# Inspector's Report ABP 319480-24

Development	4 no. wind turbines and associated works.
Location	Letter, Boleybaun, Stangaun, Greaghnadarragh, Corralustia, Turpaun, Gortnasillagh West, Lugmeeltan, Leckaun, Lisgavneen, Treannadullagh, Drumcashlagh and Corderry, Drumkeeran, Co. Leitrim
Planning Authority	Leitrim County Council
Planning Authority Reg. Ref.	2460008
Applicant(s)	Letter Wind Farm Ltd.
Type of Application	Permission
Planning Authority Decision	Refuse
Type of Appeal	1st Party v. refusal
Appellant(s)	Letter Wind Farm Ltd.
Observer(s)	<ol> <li>Joan Rogan</li> <li>John Matthews</li> </ol>
Date of Site Inspection	05/09/24 & 06/09/24
Inspector	Pauline Fitzpatrick

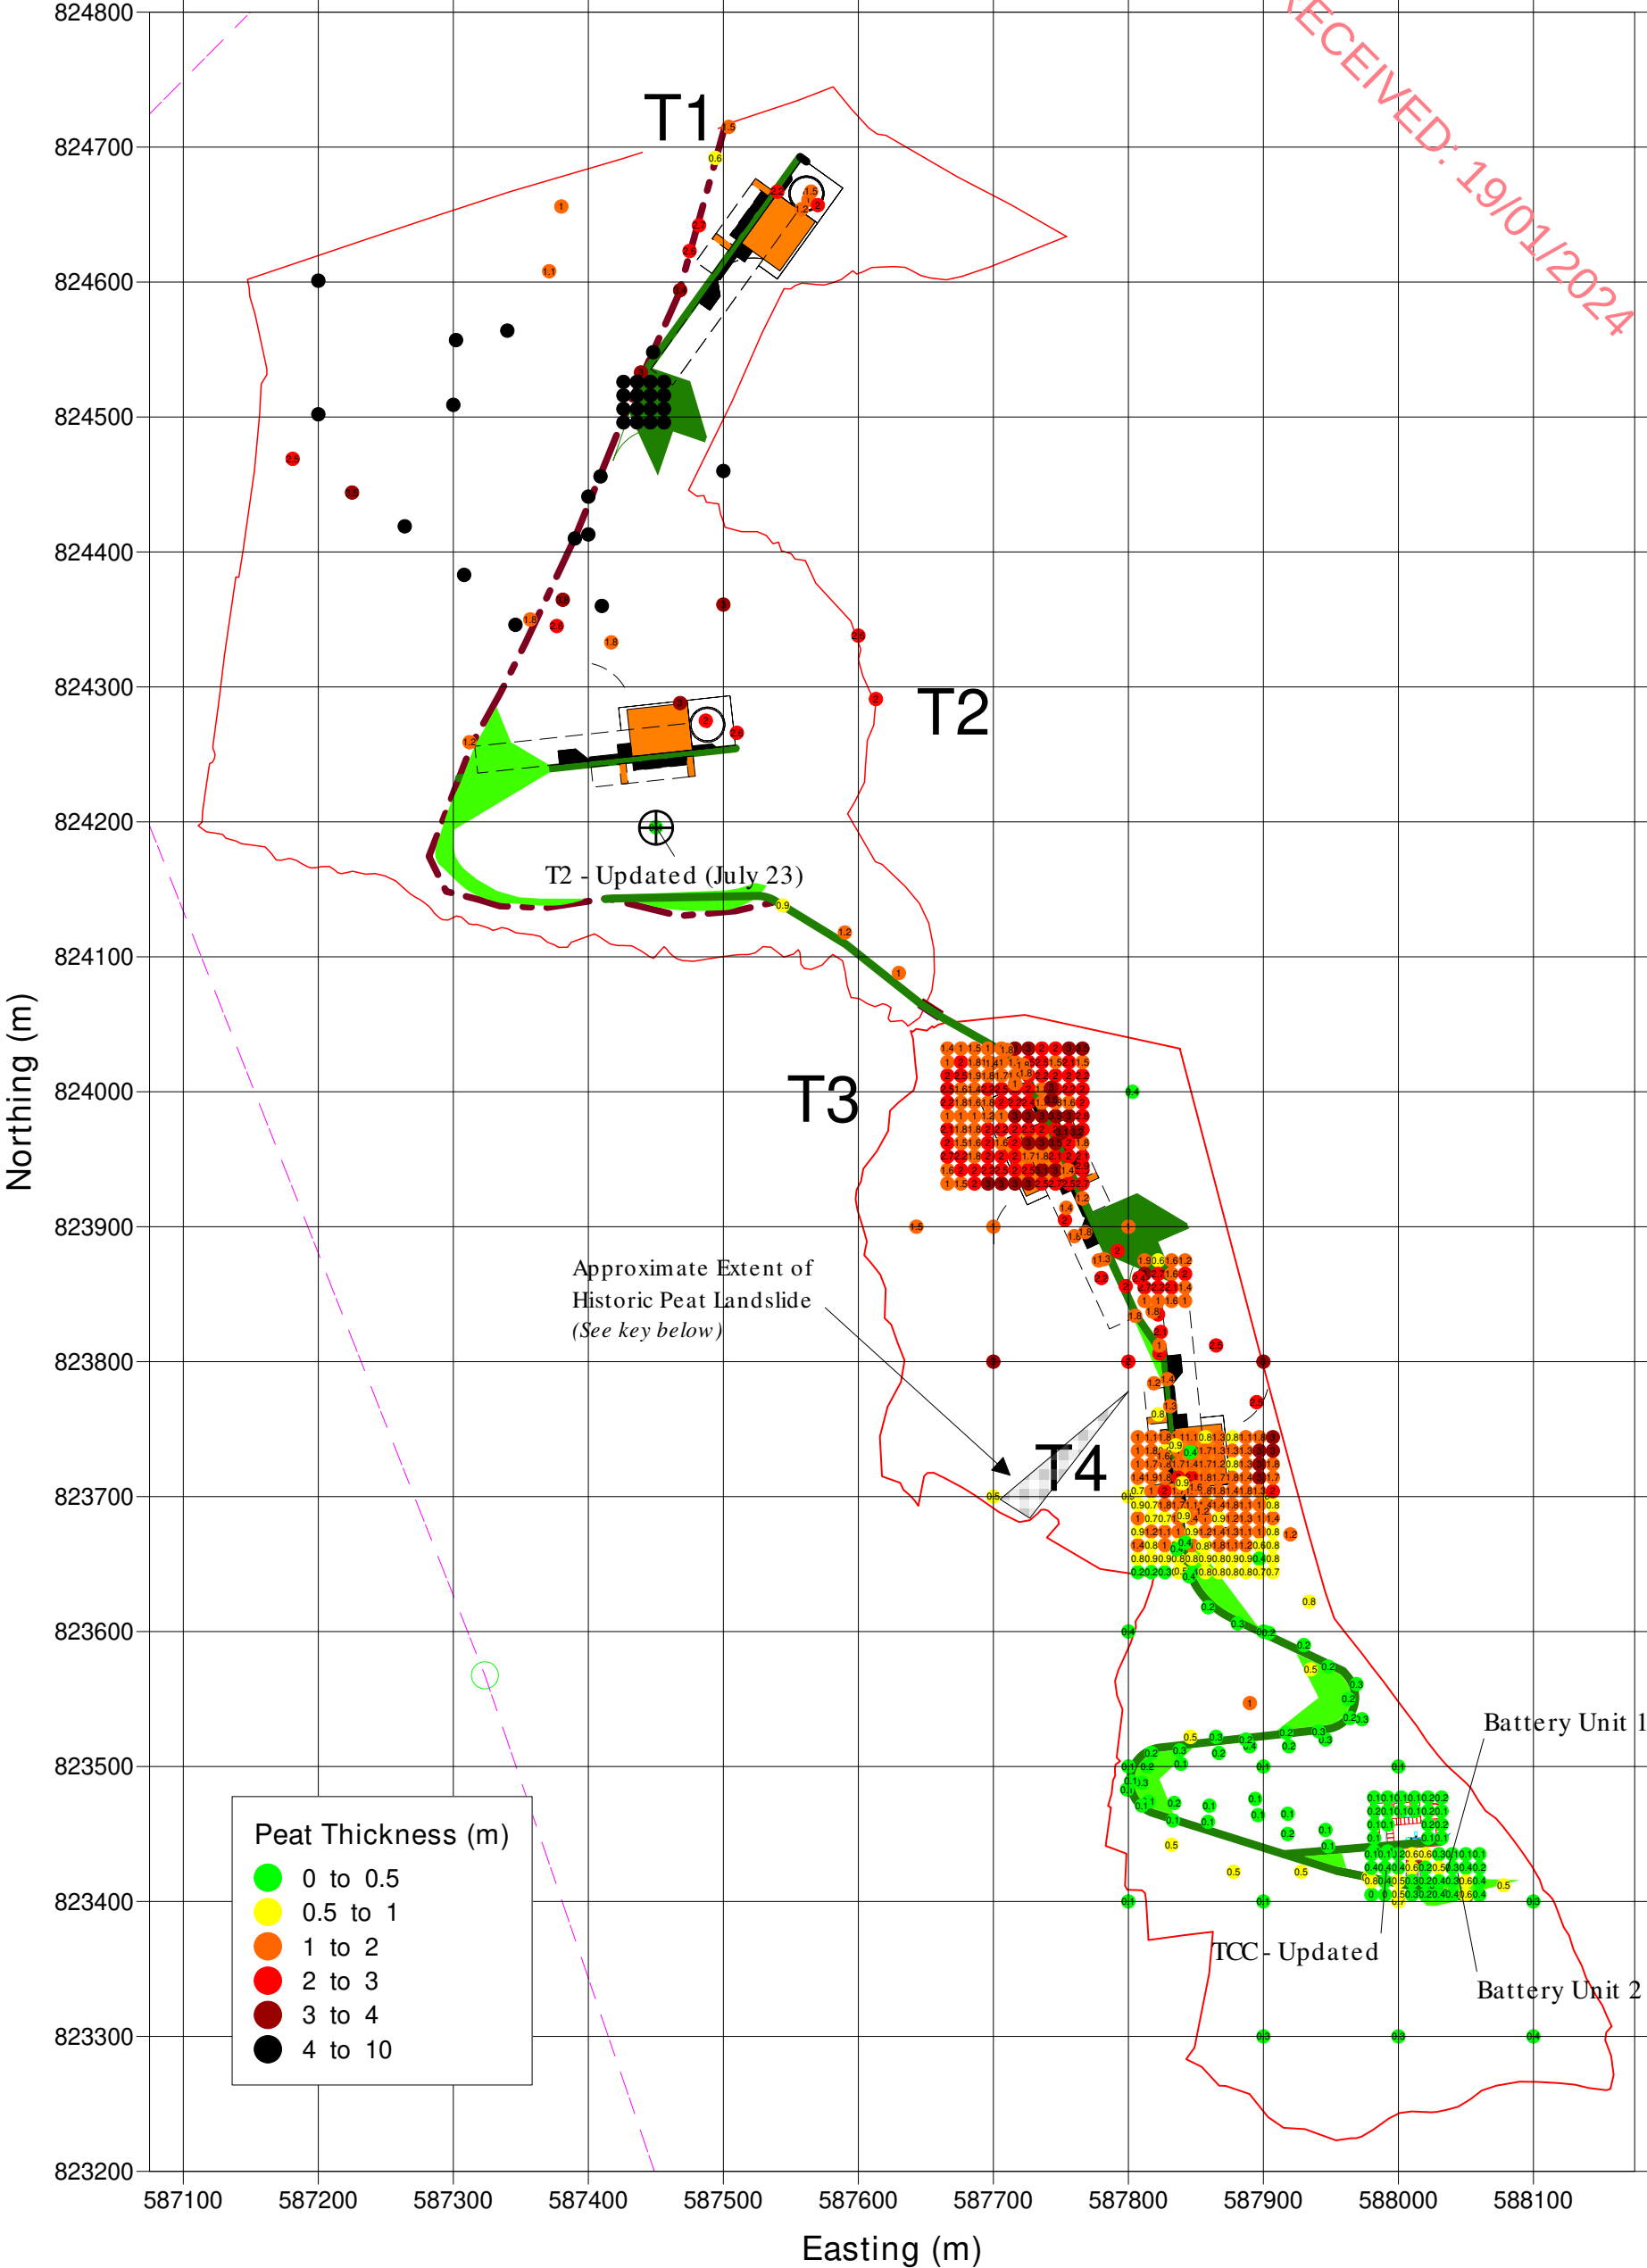
- It has concerns over peat depths at this site up to 6 metres. From its experience there are serious difficulties with developments on peat soils where there is excessive slope and where the peat depth exceeds one metre.

GSI Data Viewer - Landslide Susceptibility Map

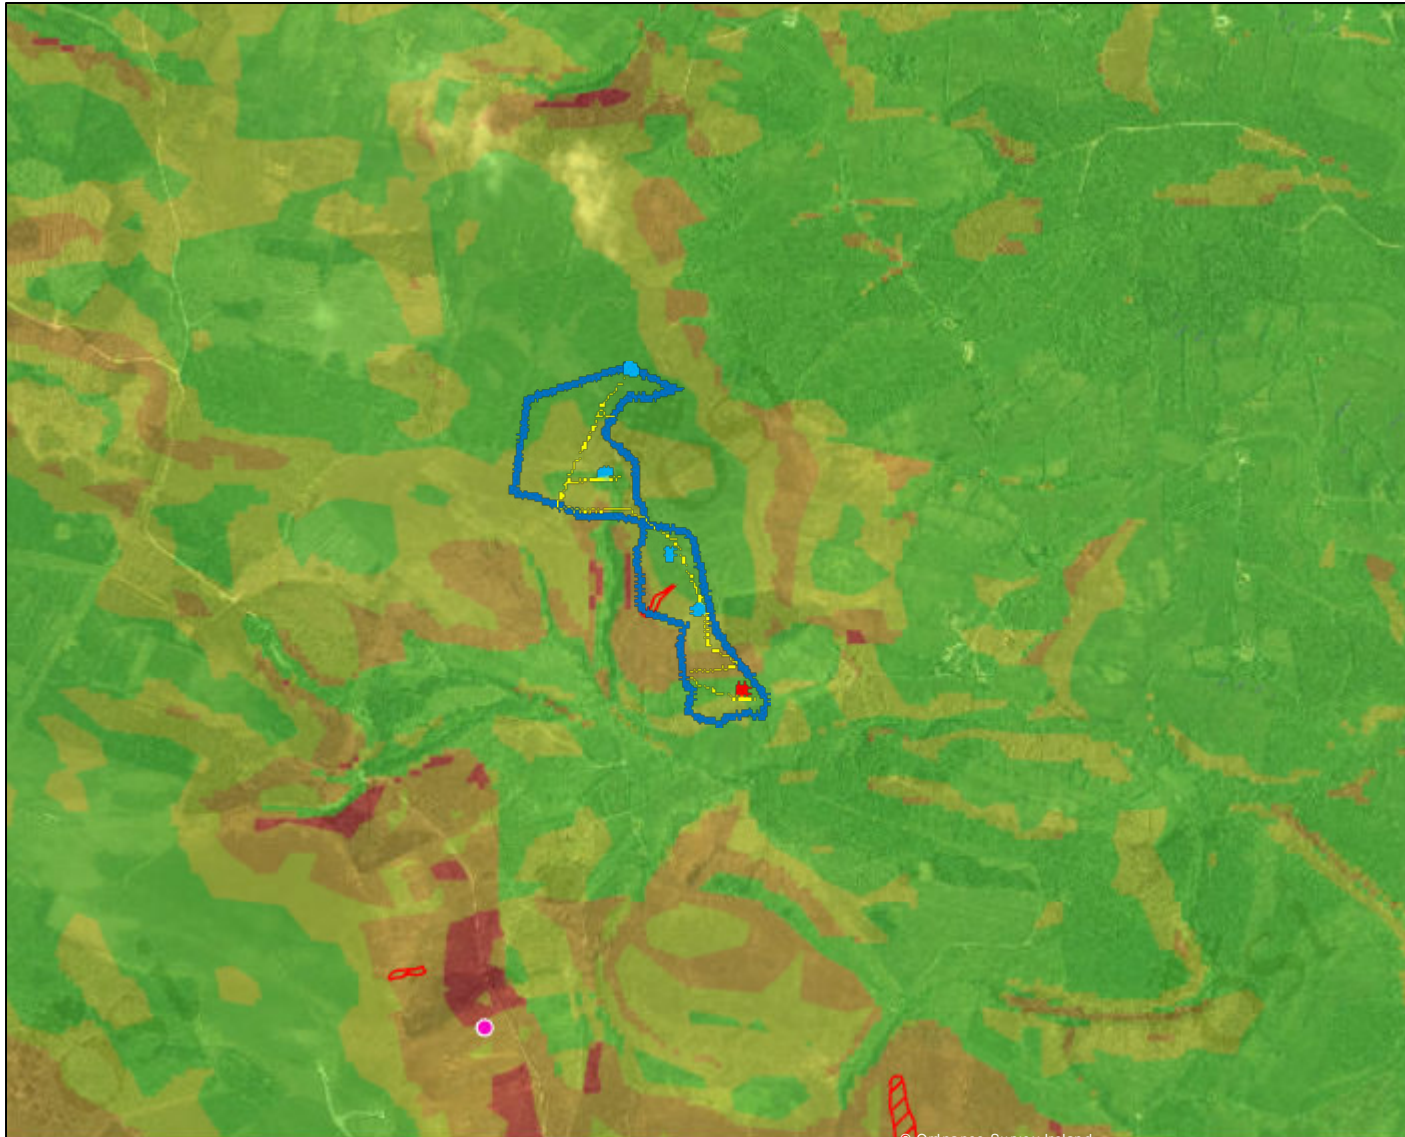
- When examined in the context of the high degree of recorded landslide events in this area, including one recorded event within the proposed wind farm site itself, the classification of the subject site as being of low to moderately high landslide susceptibility by the GSI, the upland and sloping nature of the terrain of the site, the significant depths of peat at some locations and the extensive network of drainage systems within the site, the volumes of peat and other spoil material requiring excavation, handling, storage and management, the proposed manner of spoil disposal (side casting), the identified deficiencies in the submitted PSHA and the scale of environmental damage caused by the adjacent Garvagh Glebe wind farm development as documented by the IFI in its submission on this application, it is considered that a significant level of uncertainty surrounding this issue would remain regardless of further information or clarification being forthcoming on some of the issues raised in the RPS Group Ltd. review. There is a real and inherent risk of peat failure and/or landslide associated with the construction stage of the proposed development.
